SUBJECT: Engineering Review Comment
Mountain View Electric Association Inc. (MVEA)

Project Name: Copper Chase at Sterling Ranch – Final Plat

Project Number: SF2316

Description: A proposed development of 138 residential lots and 10 tracts on approximately 20 acres located southeast of Vollmer Rd. and the future Marksheffel Rd. in Township 13S, Range 65W, Section 05.

**AS REPLATTED**

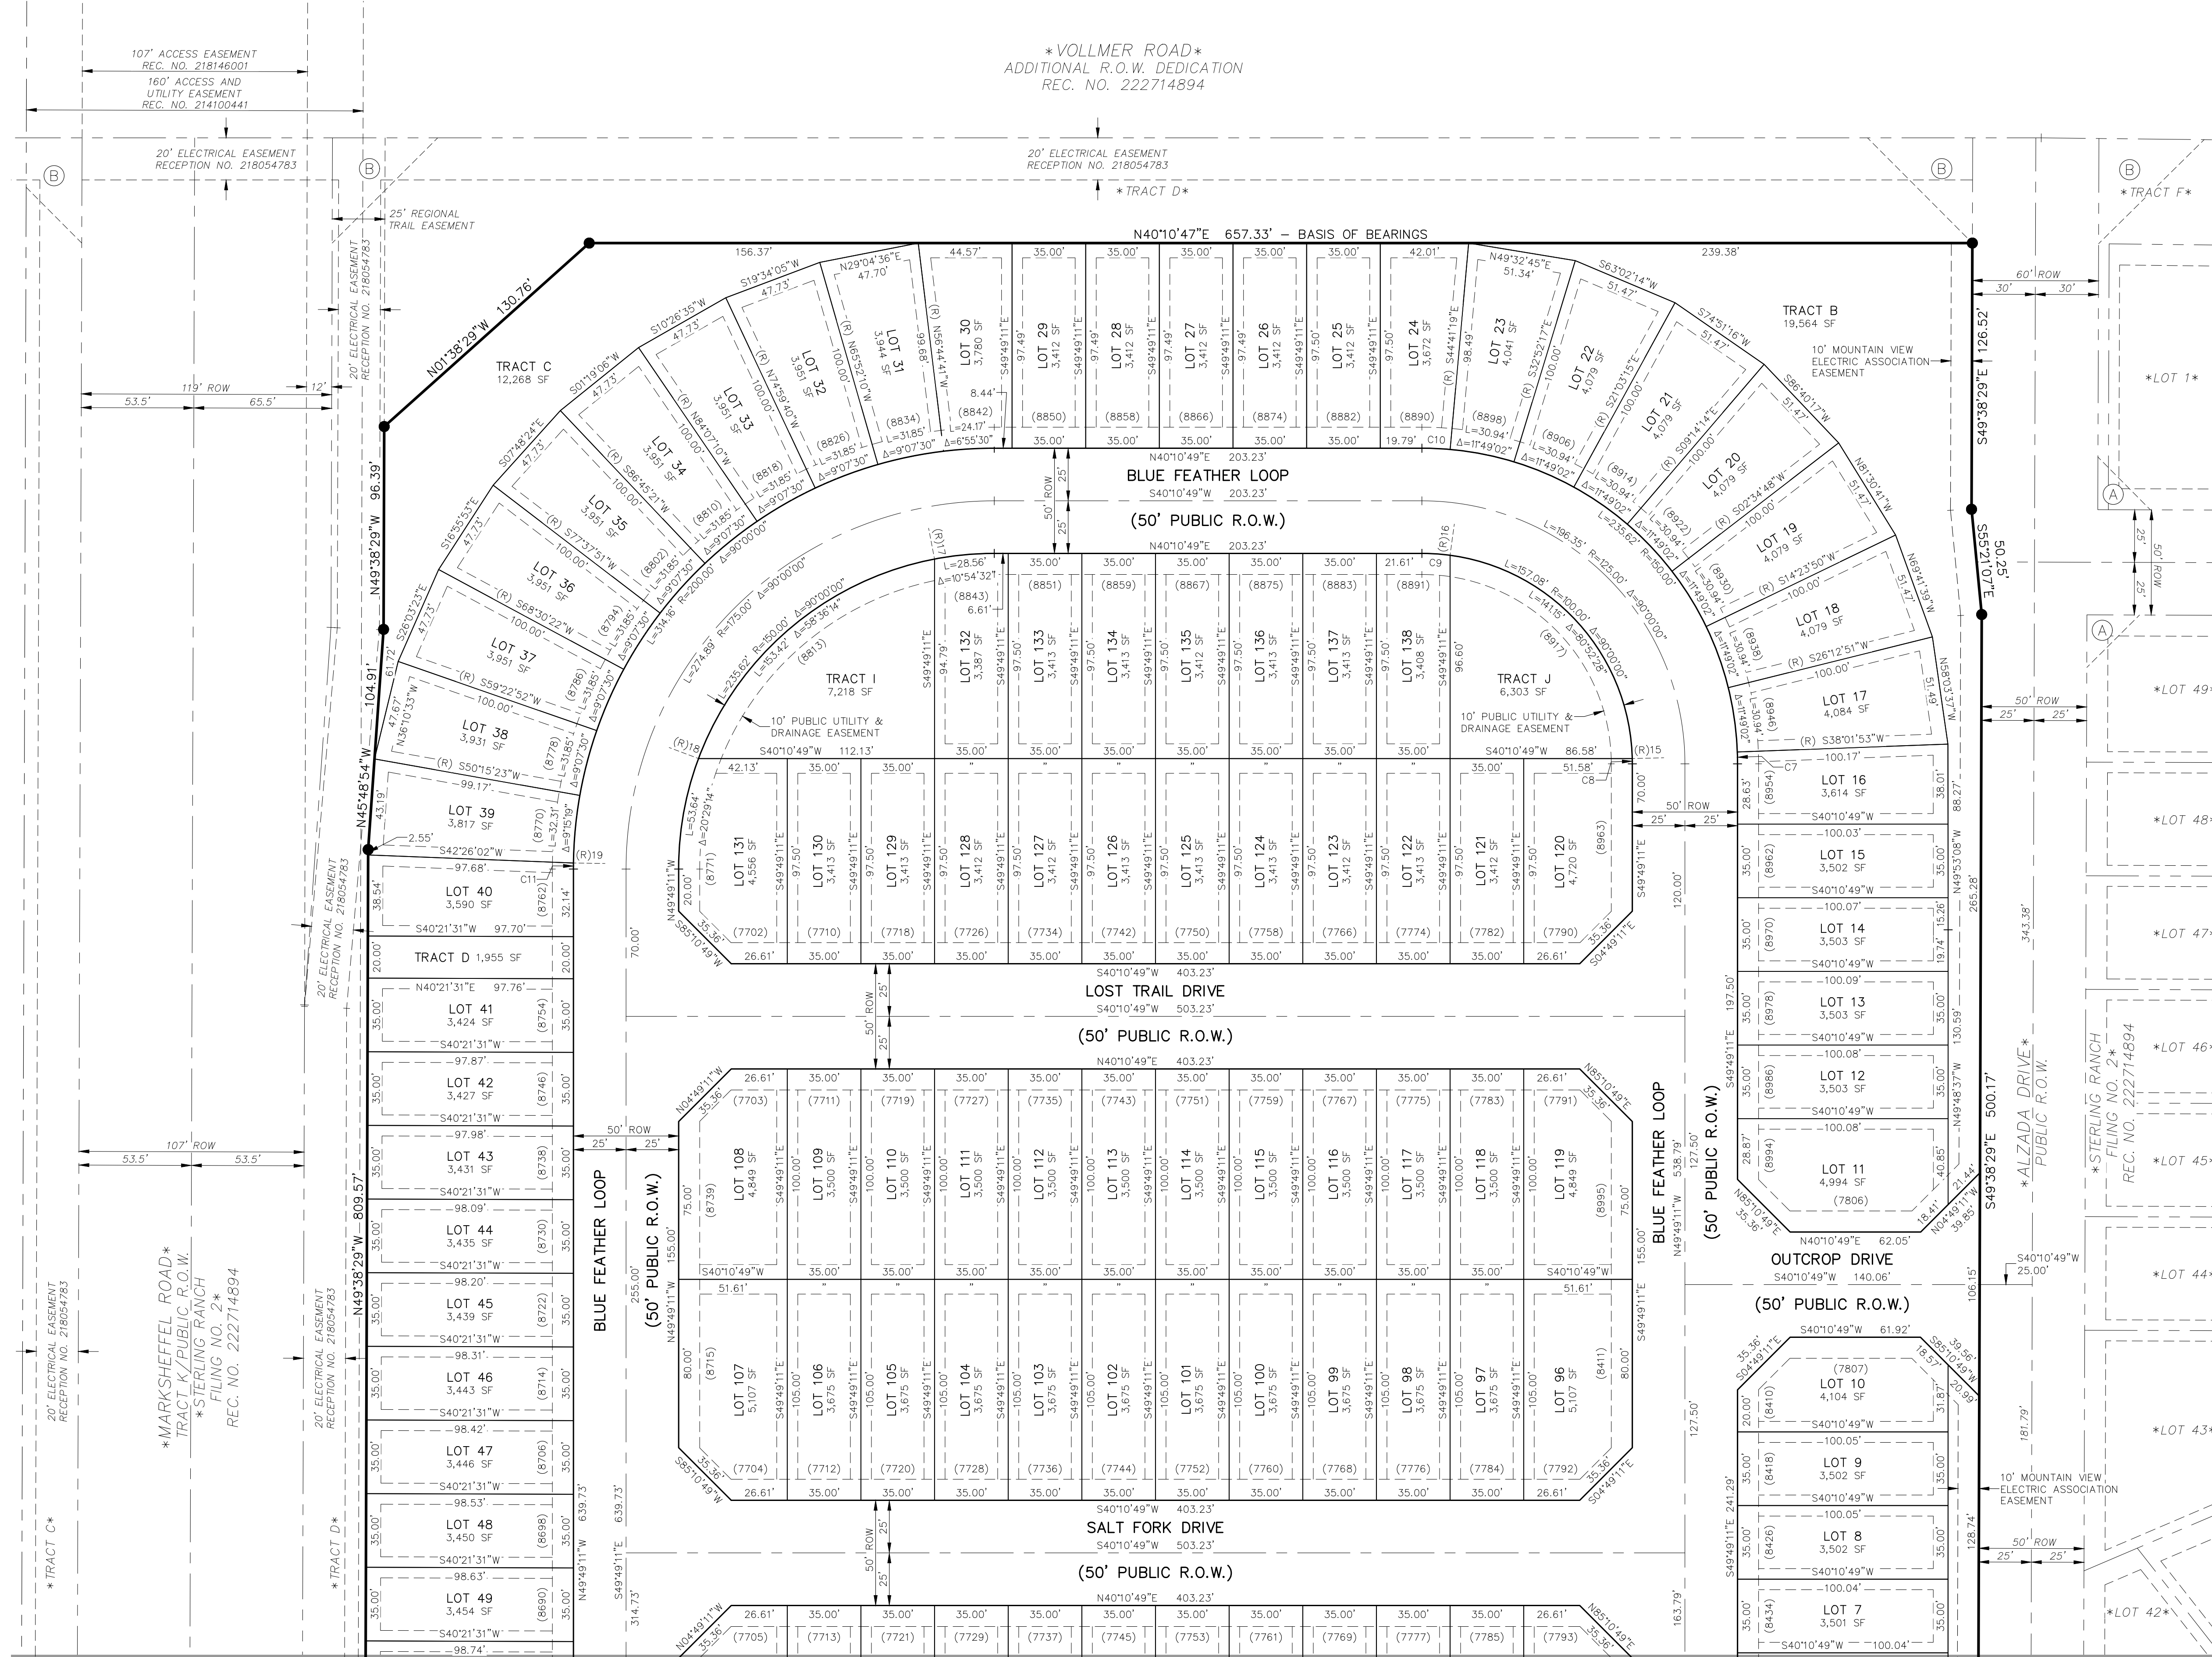
If no public improvement easement, MVEA requests the front lot line easement to be a ten (10) foot public utility easement instead of a five (5) foot public utility easement with a ten (10) foot private easement. MVEA also requests the platting of MVEA's existing facilities with easements on the plat. Additional easements may be required.
